M60/M62/M66 Simister Island Interchange Project

Application by National Highways for an Order granting Development Consent for the M60/M62/M66 Simister Island Interchange Project

Summary Statement on behalf of the Hillary Family

FIGURE 2.3

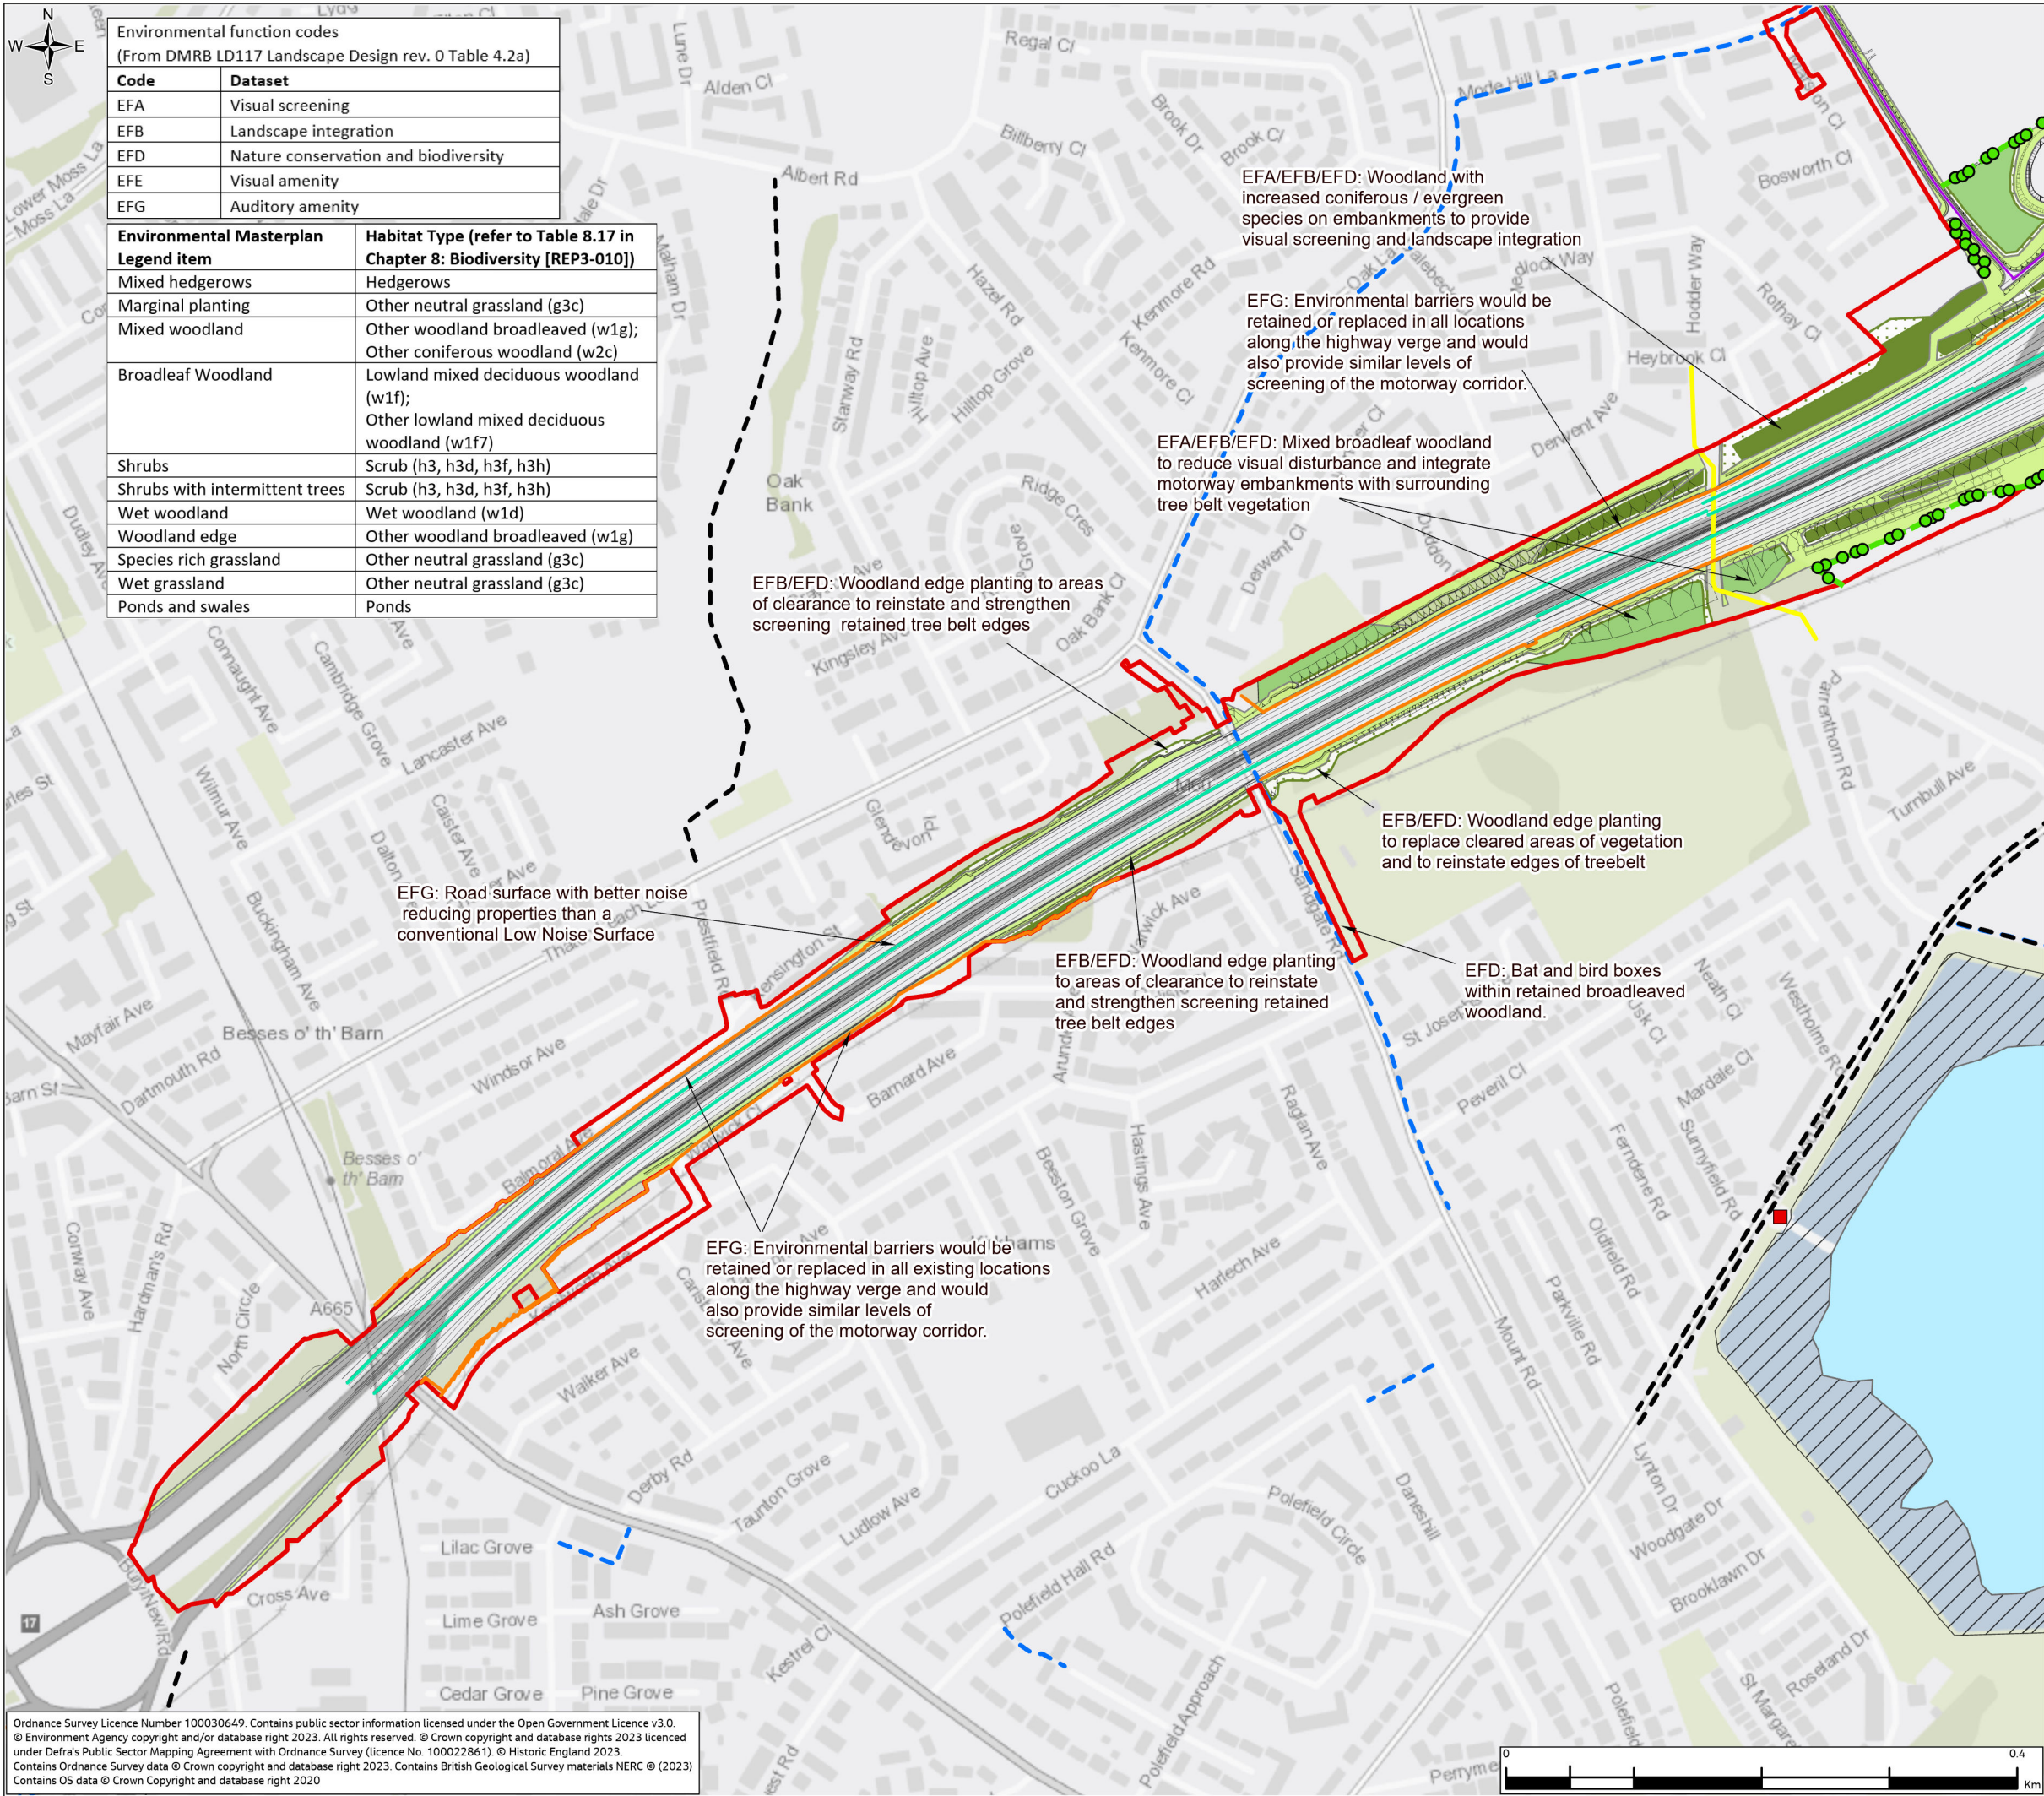
- i. Commitment LV5 relates to land adjacent to the EMAs. It is not relevant to the EMAs, and nor does it justify the need for powers to permanently acquire the EMAs.
- j. The Environmental Masterplan [APP-057] demonstrates that hedgerows can be provided on the Northern Loop embankments and/or along the existing Egypt Lane verge. Commitment LV6 does not justify the need for powers to permanently acquire, the EMAs themselves.

- k. Commitment LV10 relates to *the Northern Loop embankments and land within the Northern Loop*. It does not relate to the EMAs and does not justify the need for powers to permanently acquire the EMAs themselves.
- l. While Commitment LV15 does expressly refer to land east of the Northern Loop, it does not refer to the EMAs. The applicant considers that sufficient planting can be provided on the Northern Loop embankments so as to provide the mitigation described, and Commitment LV15 does not amount to a compelling justification for the powers sought in respect of the EMAs.

Similarly, the Hillary Family repeats and maintains its comments regarding attenuation pond 1 and its outfall drain, in that it considers these features could either be located inside the Northern Loop or drawn much tighter to the footprint of the Northern Loop so as to reduce the land take from the Hillary Family.
